# **Comments appertaining to ESSO's response to RBC's written representations 1 (Deadline 2)**

**Application by ESSO Petroleum Company Ltd  
for an Order Granting Development  
Consent for the Southampton to London  
Pipeline Project**

**Application Reference EN070005**

**Internal Reference 19/00432/PINS**

© Crown copyright and database rights 2020 OS Licence Number AL10005237

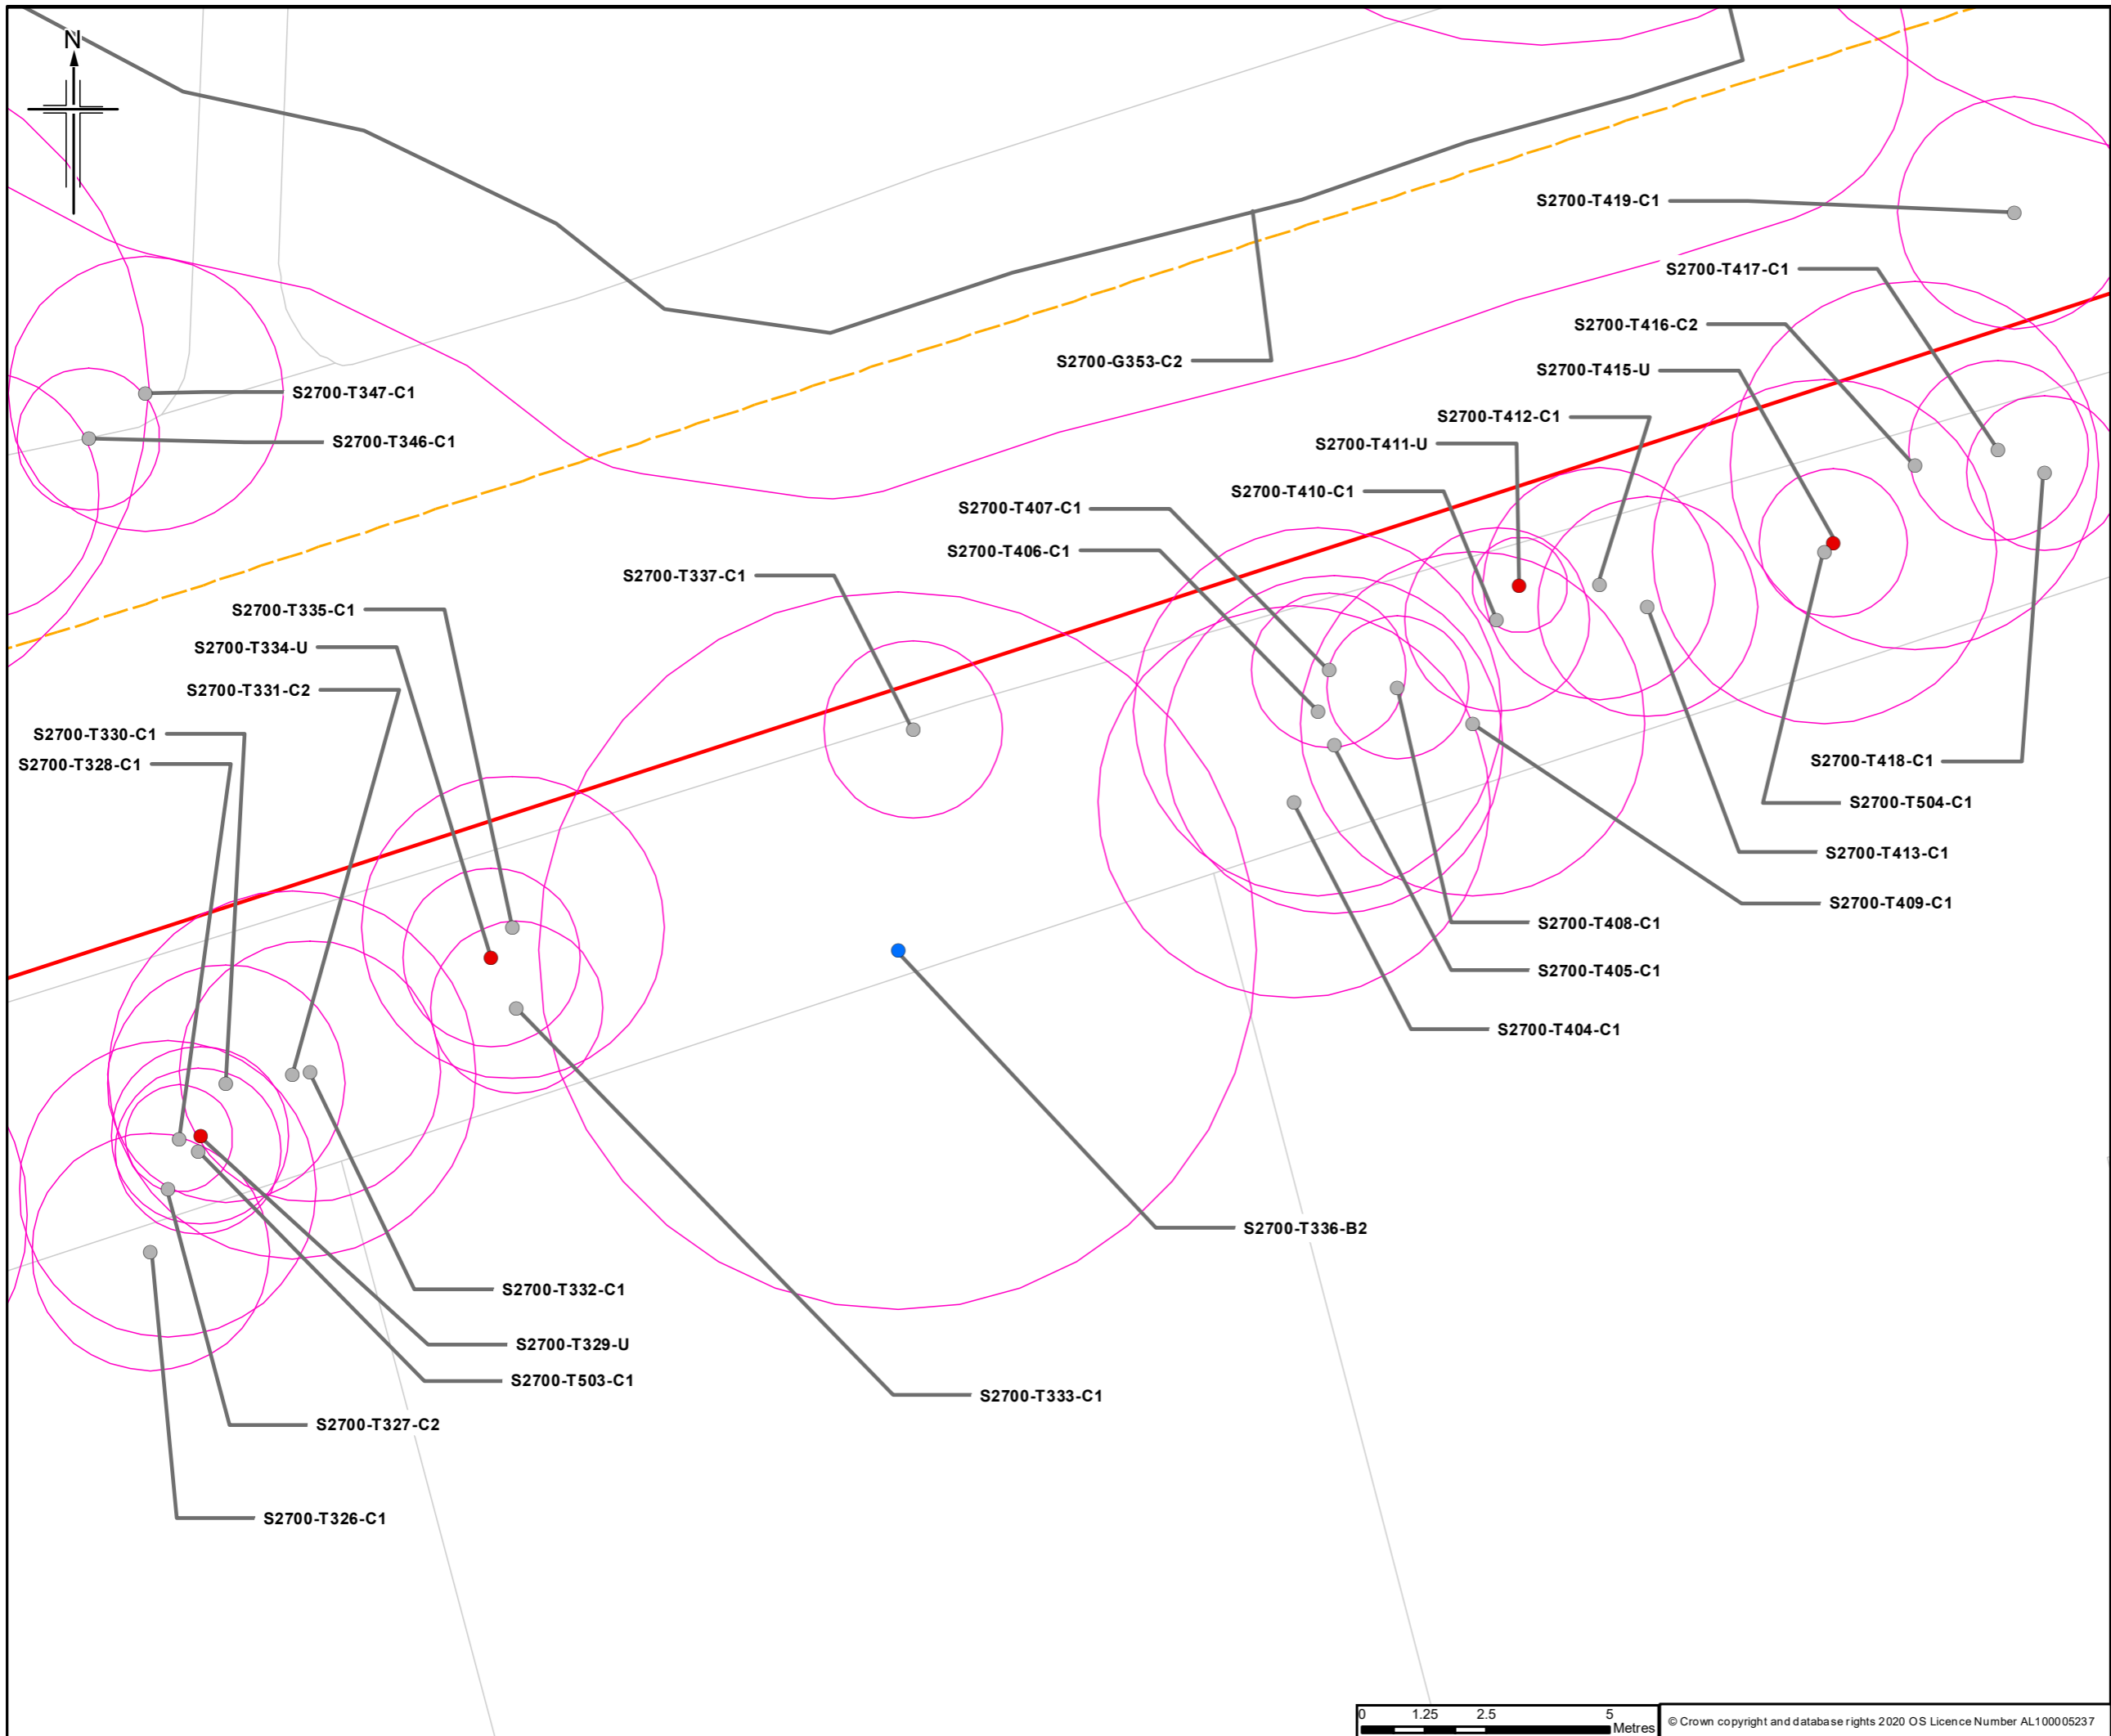
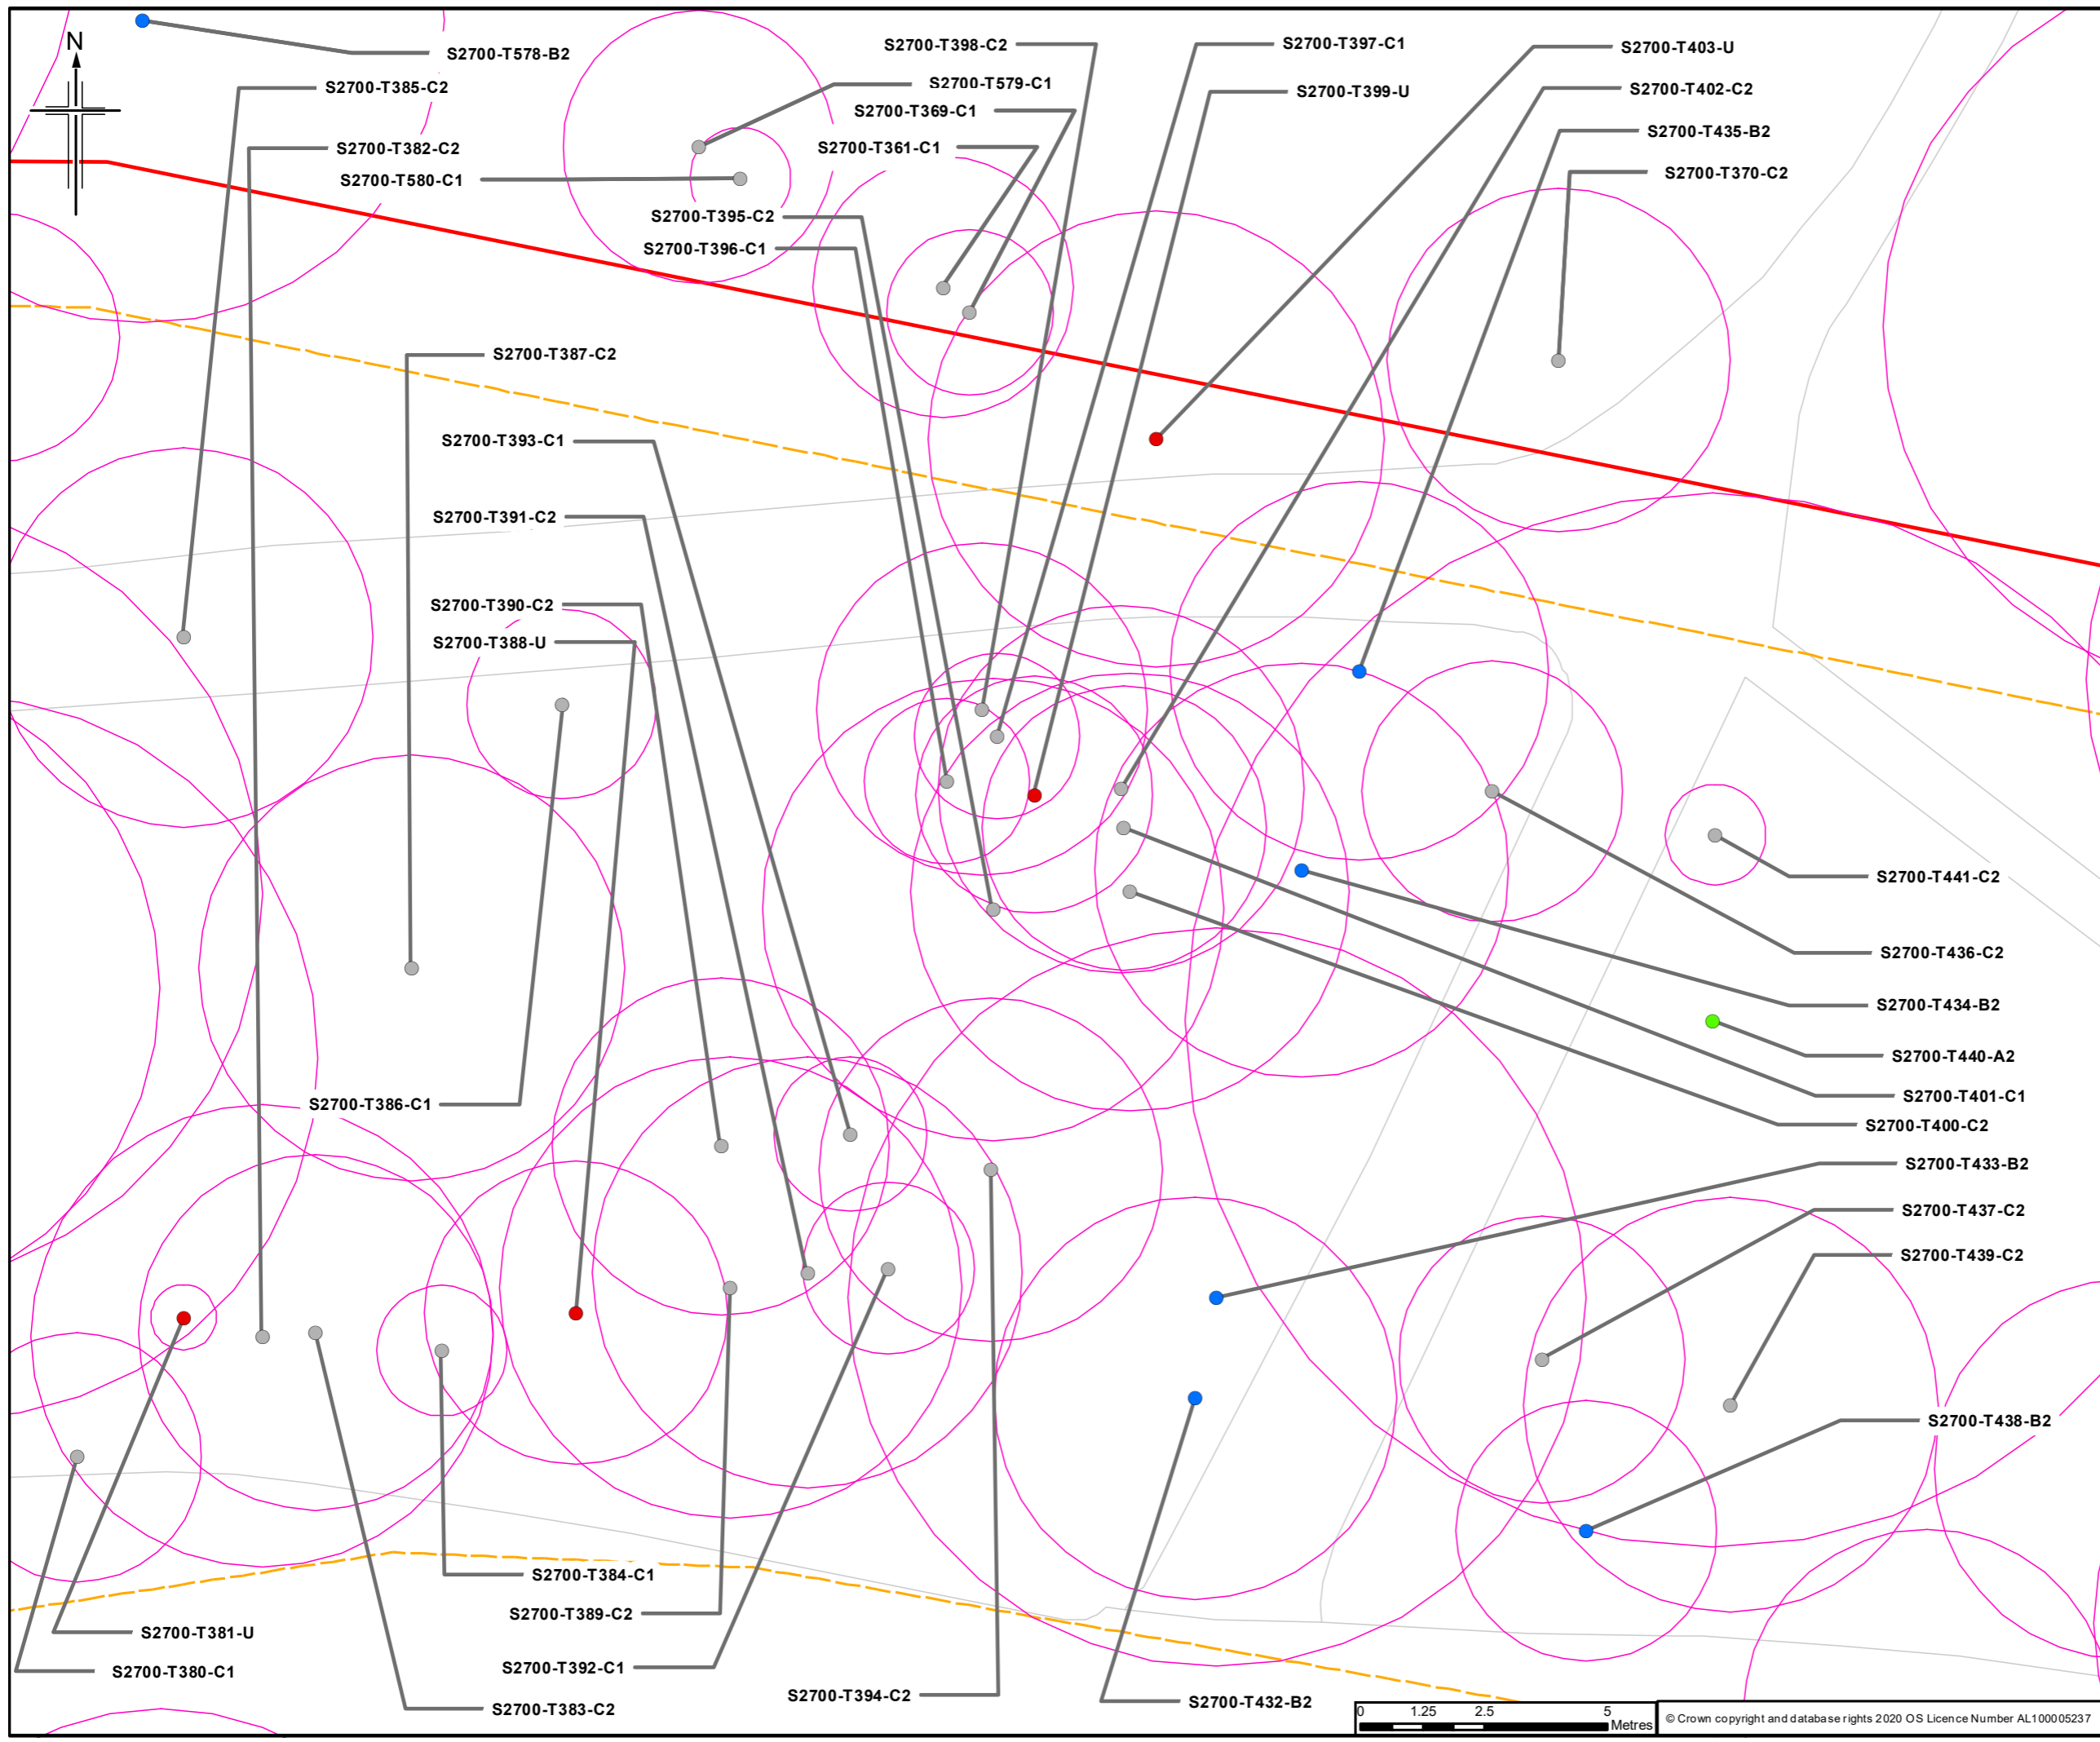
- 4.4 In respect of Queen Elizabeth Park the council would have expected this site to be surveyed due to the significant loss of the priority mixed broadleaved deciduous woodland. However the original survey missed many notable and veteran trees and therefore their loss was not

- 4.6 The council is particularly concerned regarding the assessment undertaken within Queen Elizabeth Park. Although many trees within the order limits appear to contain bat potential, with a significant number of notable and veteran trees present within the park, only two trees were climbed. The council has agreed for ESSO to undertake further bat and tree condition surveys within QEP which RBC understands are to be submitted at deadline 4. If we still feel that the information is inadequate we intend to undertake our own survey which we will submit before the next hearings, along with comments on the next steps required.
